**M1 Pacific Motorway extension to Raymond Terrace (SSI 7319)
Advice on the Environmental Impact Statement (EIS)**

Thank you for the request for advice from Public Authority Consultation (PAE-24749572), requesting the review by the NSW Environment Protection Authority (EPA) of the Environmental Impact Statement (EIS) for the proposed M1 Pacific Motorway extension to Raymond Terrace (Application SSI-7319).

ATTACHMENT A: EPA COMMENT ON EIS FOR M1 PACIFIC MOTORWAY EXTENSION TO RAYMOND TERRACE (SSI 7319)

Location: L05 - 11 Anderson Drive, Tarro, Tarro

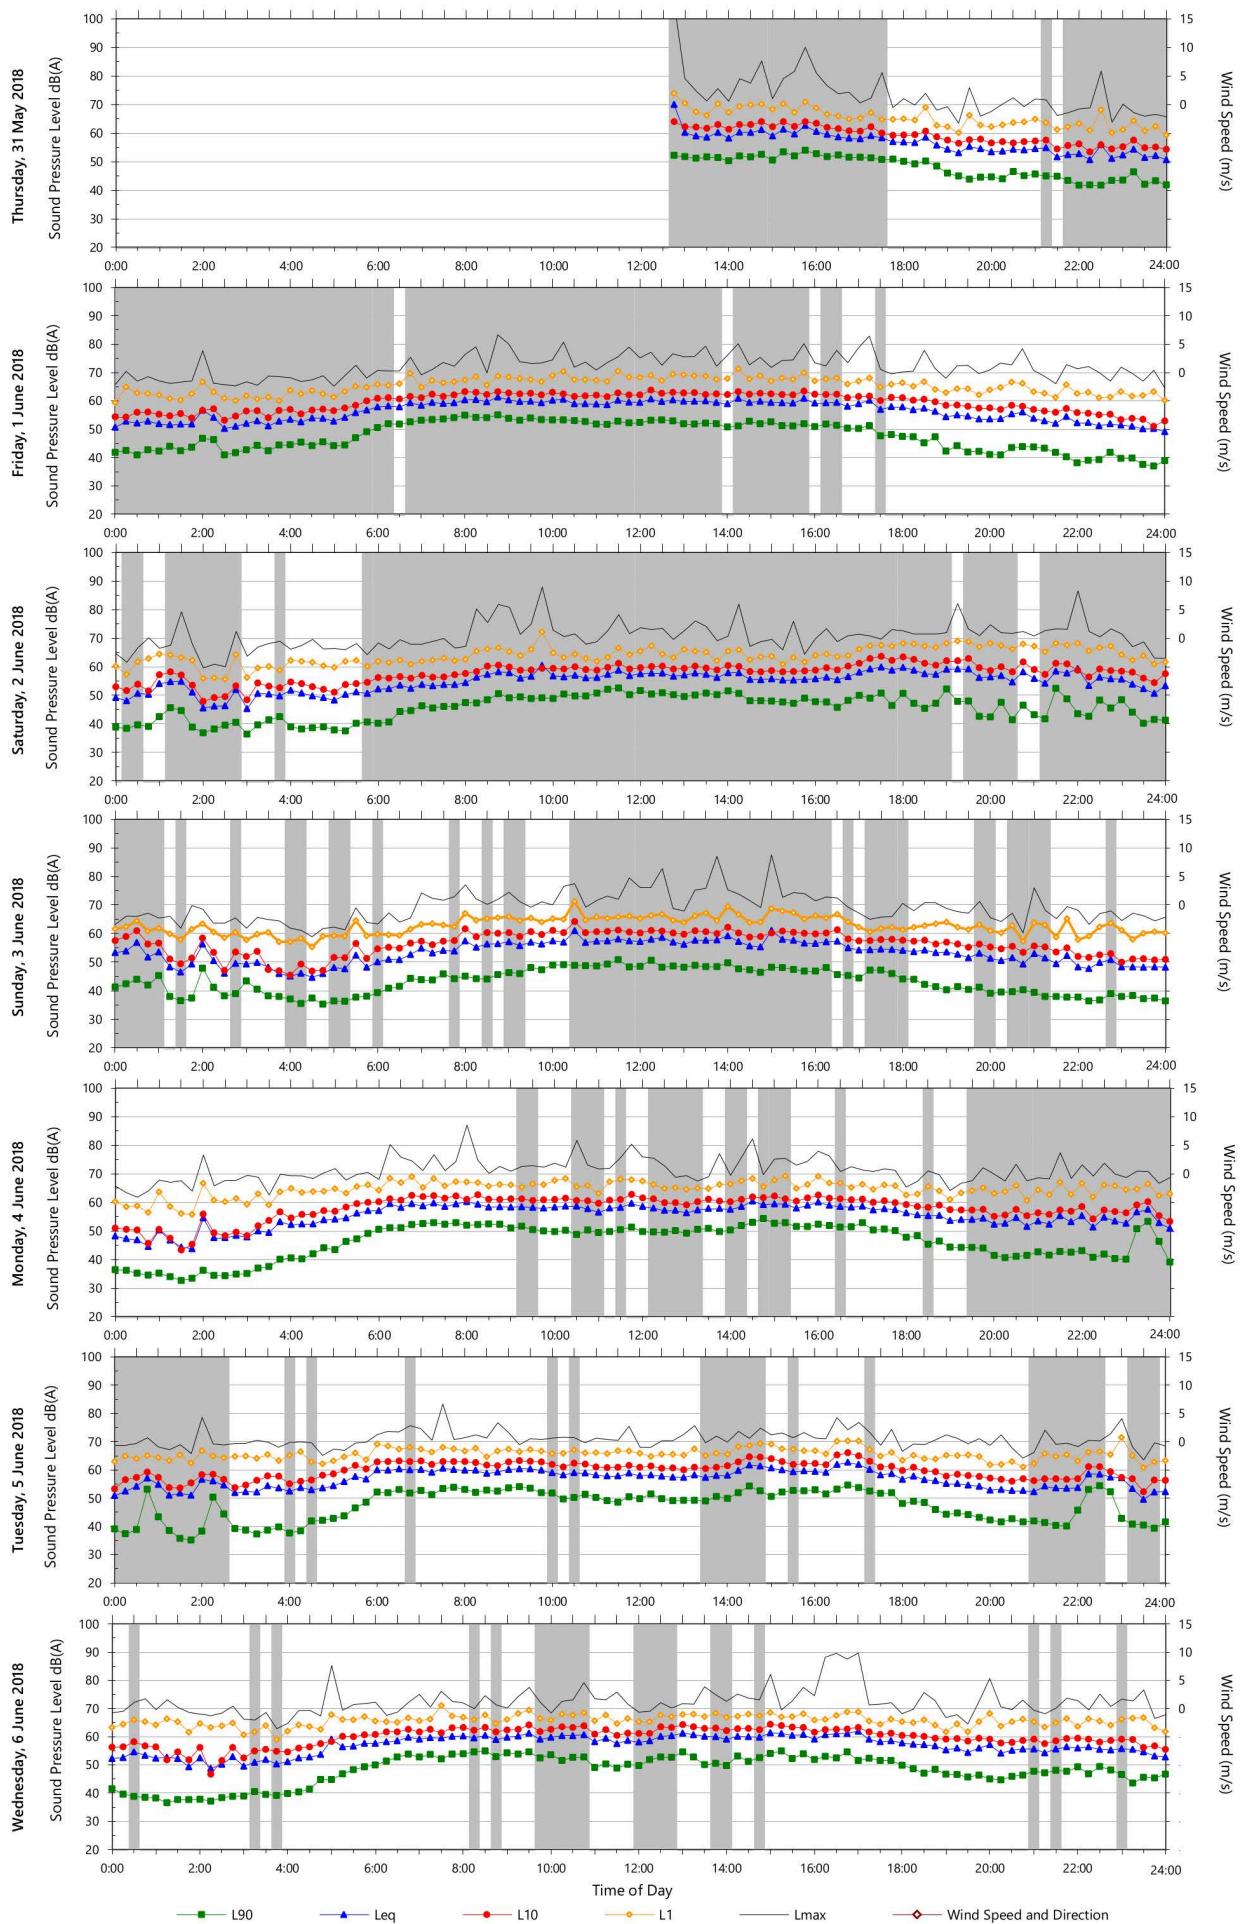
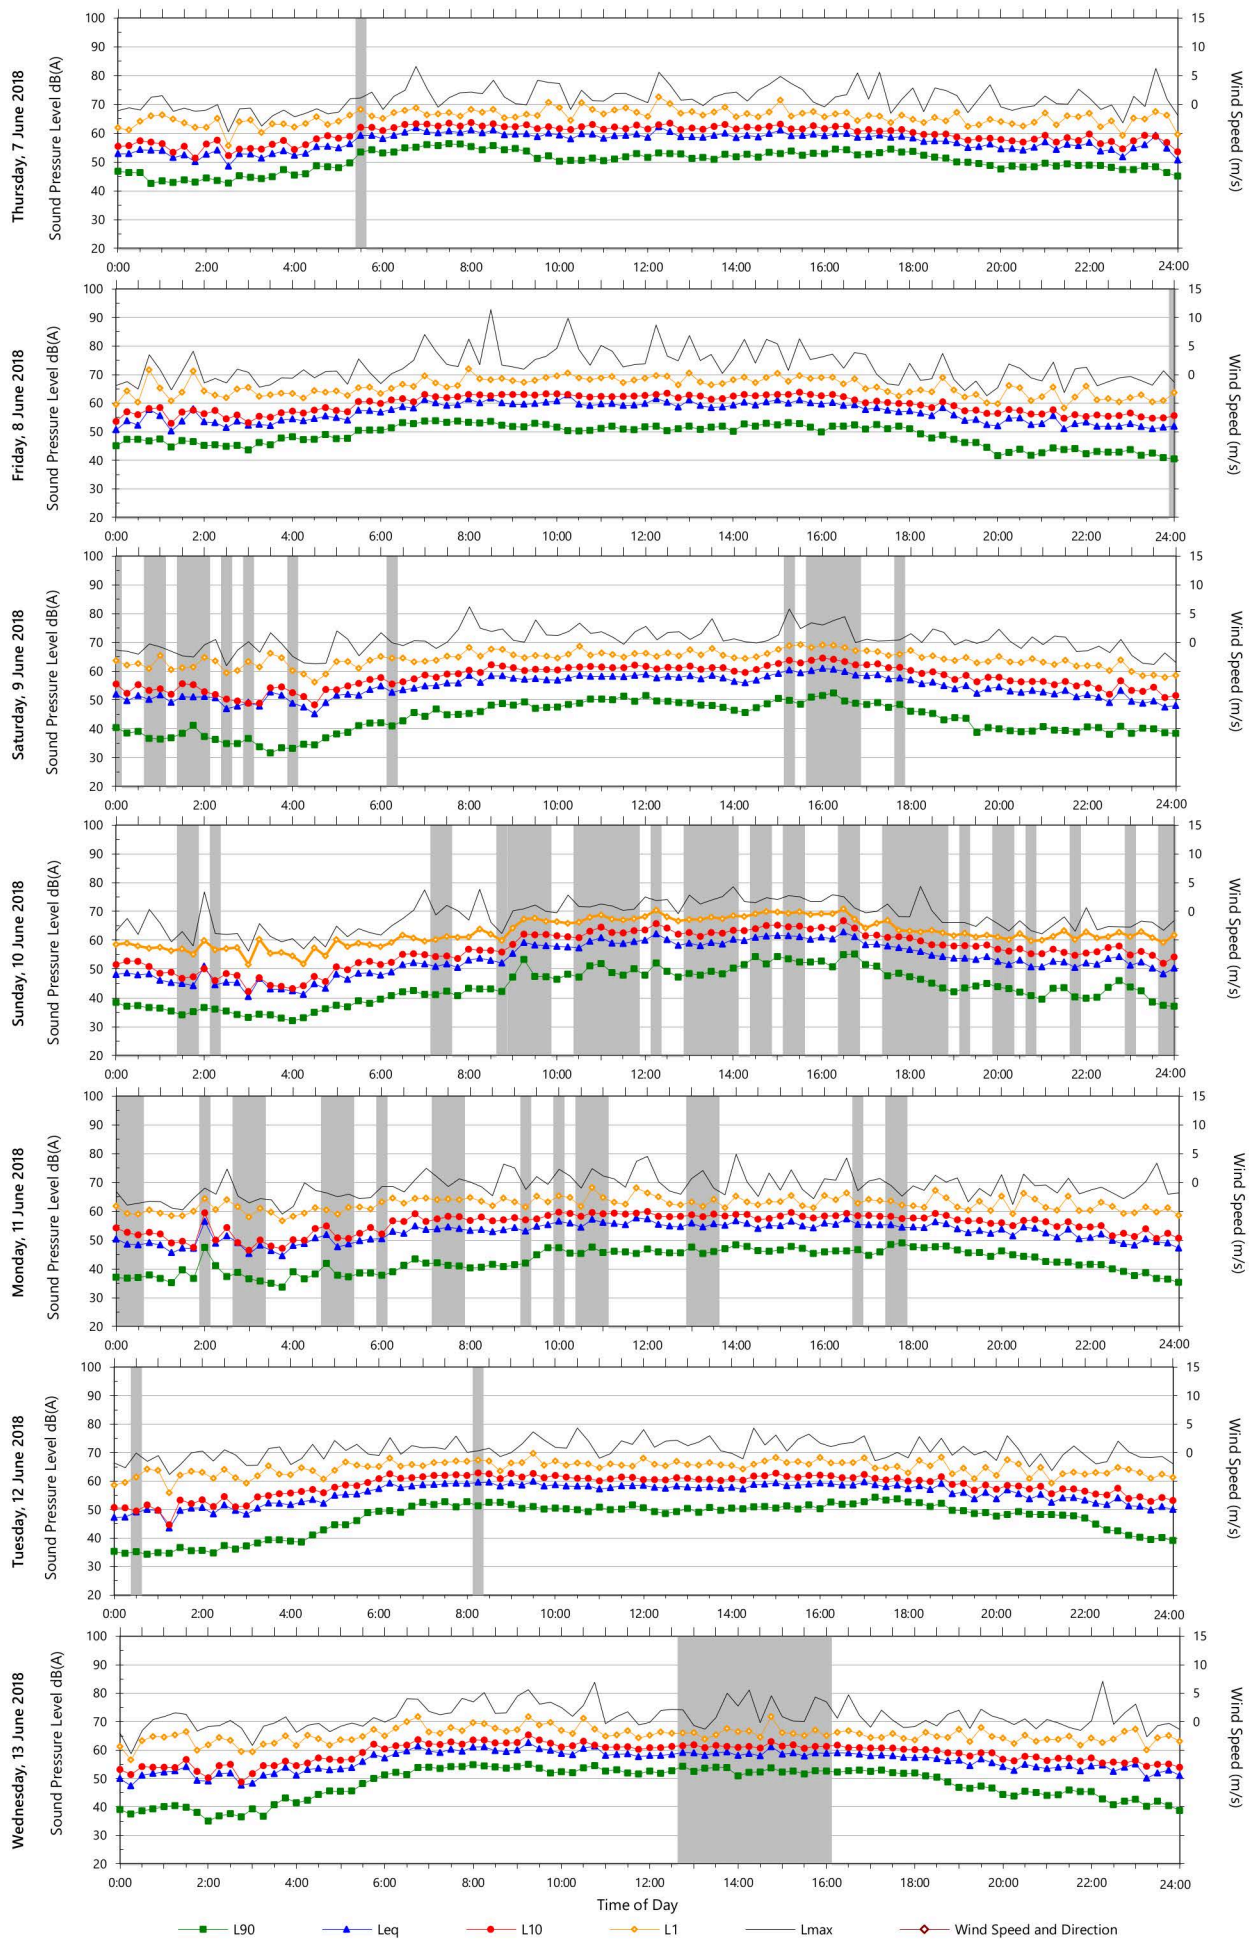
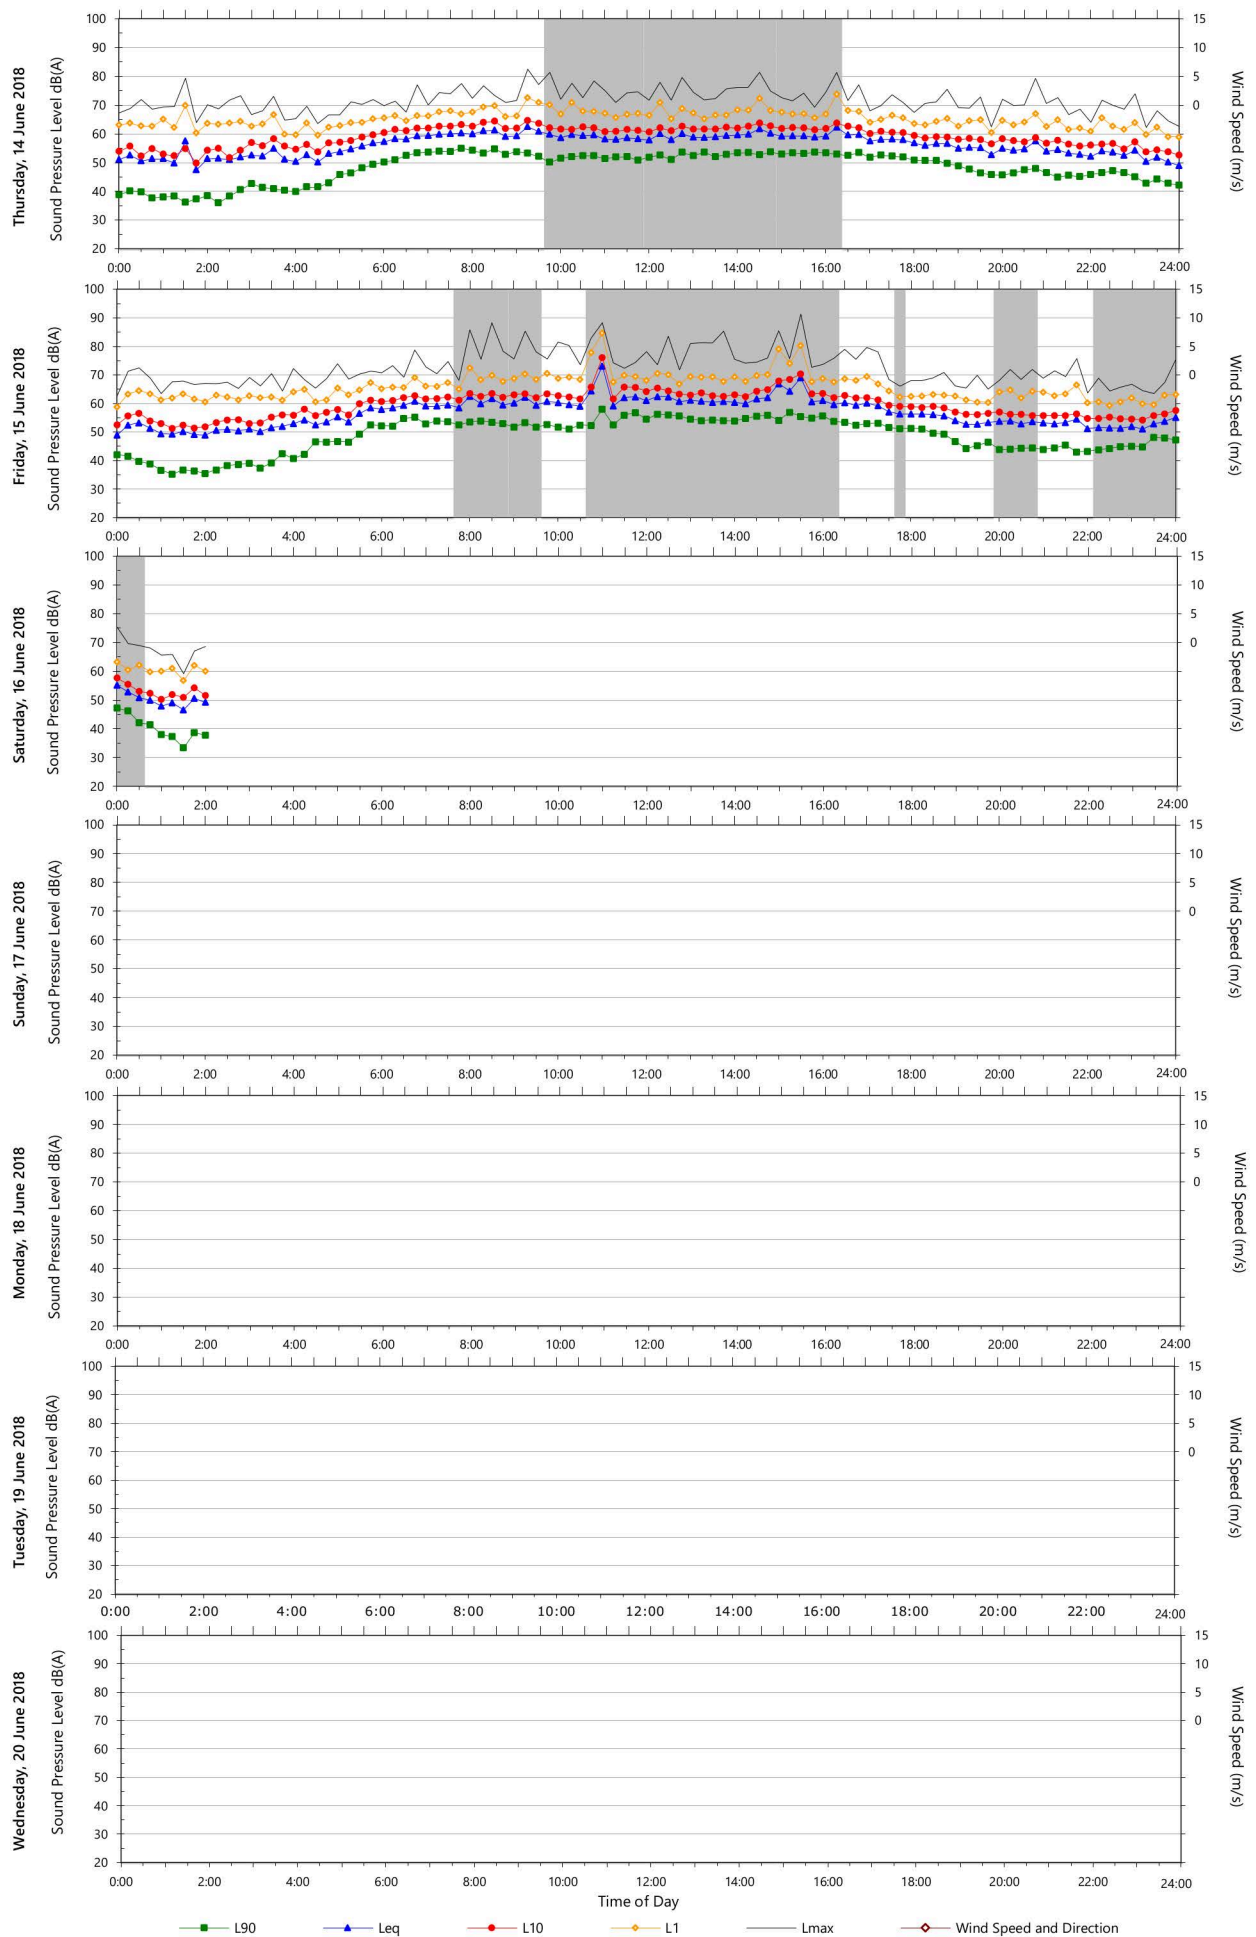
A review of the noise monitoring graphs in NIA Appendix B.2 indicates that further justification for the adequacy of noise monitoring presented or additional information is required.

A significant amount of data appears to have been excluded due to either inclement weather or extraneous noise. The EPA is concerned that the extent of data excluded means that it may not be representative of long term background noise levels, and therefore its suitability to be used to establish reliable noise management levels could be called into question.

Locations L01 to L014 (inclusive) appear to have no more than 5 and in some cases less than 3 valid periods out of the total monitoring duration. Locations L15 to L20 appear to be less affected, however there it is still not clear if sufficient valid data has been presented.

Fact Sheets A and B in the Noise Policy for Industry (NPfI) set out the EPA's requirements for establishing background noise levels. Due to the amount of data excluded, it is currently not clear if these requirements have been satisfied nor if sufficient valid data has been presented in order to establish representative background noise levels.

Noise monitoring was also conducted in 2016 for the purposes of measuring road traffic noise. Due to the amount of data excluded at Locations L13 to L20, further justification is needed that the remaining data, after invalid samples were excluded, provides sufficient amount of data to enable a representative calculation of the traffic noise descriptors.

The proponent reviews the noise monitoring data in the NIA in the context of the monitoring requirements set out in the NPfI and for each location and either:

- Provide a justification and demonstrate that the requirements of the NPfl have been fulfilled; or
- Provide additional data that fulfills the monitoring requirements in the NPfl.

The EPA also recommends that the proponent either:

- Provides justification and demonstrate that the data presented for road traffic noise descriptors is sufficient to be representative; or
- Provides additional valid data.
